App. No: 3/2025/0194
Proposal: Proposed conversion of garage to form additional living space. Addition of window to side elevation. The front elevation will be unchanged.
Location: 27 Poplar Way Barrow BB7 9ZN

Amended plans have been received and the following updated comments are made.

EXISTING AND PROPOSED SITE PLAN.

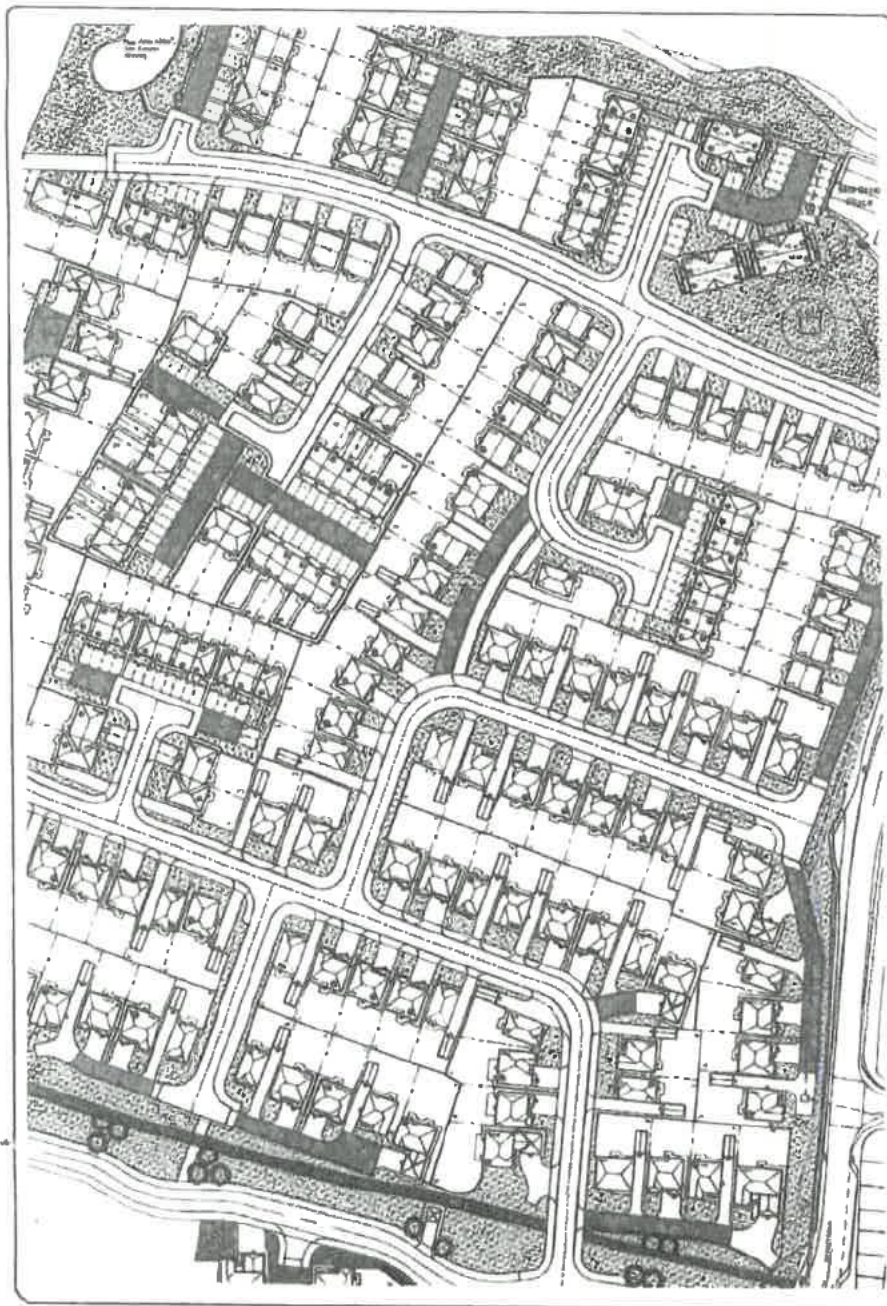
There are 2 existing driveway spaces at the dwelling and due to the loss of the garage parking space we would request that an additional space is provided on the driveway to provide an overall provision of 3 off-street spaces to accord with the parking standards for a 4 bedroom dwelling.

A drawing is submitted to show an additional space on the driveway measuring 2.4m by 4.8m which is acceptable.

The driveway should be constructed in a bound and porous material.

The vehicle crossing on Poplar Way will need widening for the full width of the driveway. Poplar Way is still under the responsibility of the developer therefore the householder will need to obtain the developers permission prior to the vehicle crossing being constructed.

1. Prior to the first use of the development hereby permitted, the additional driveway space shall be completed with the vehicle crossing widened for the full width of the driveway. Reason: To provide adequate car parking provision at the dwelling.
